NOTICE TO CONTRACTOR
All construction shall comply with current NC Building Codes
and is subject to field inspection and verification.

APPROVED
Contract Building with License
Permit holder responsible for
full compliance with the state.

193 CLEARVIEW COURT
1ST Floor

Foundation Plan

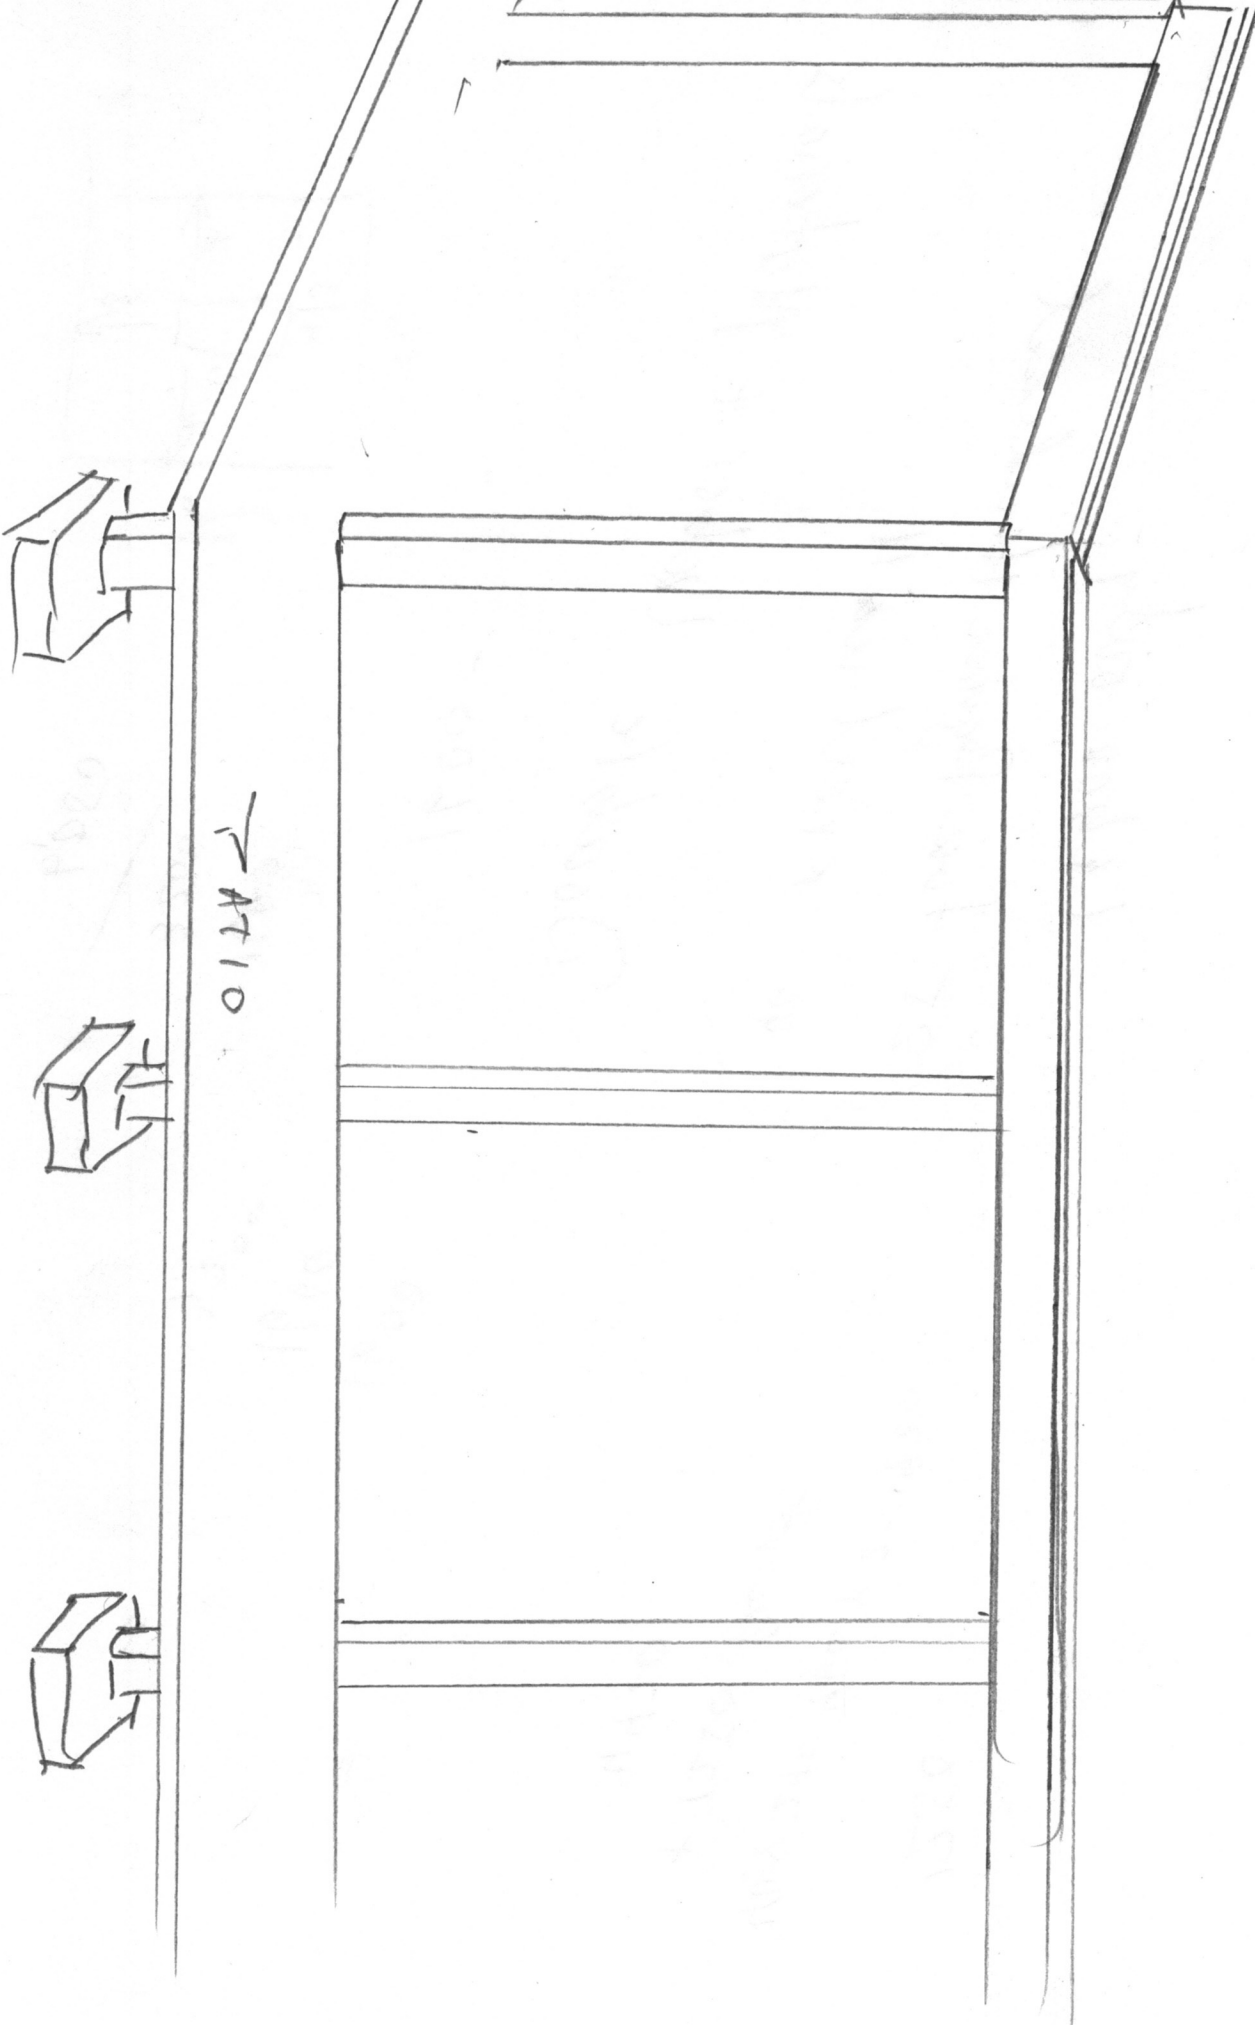
See notes next
page

Per contractor
05/04/2023 Larry Gavin,
the slab will be cut away
around perimeter, and a
continuous footing
poured. and post bases
installed.
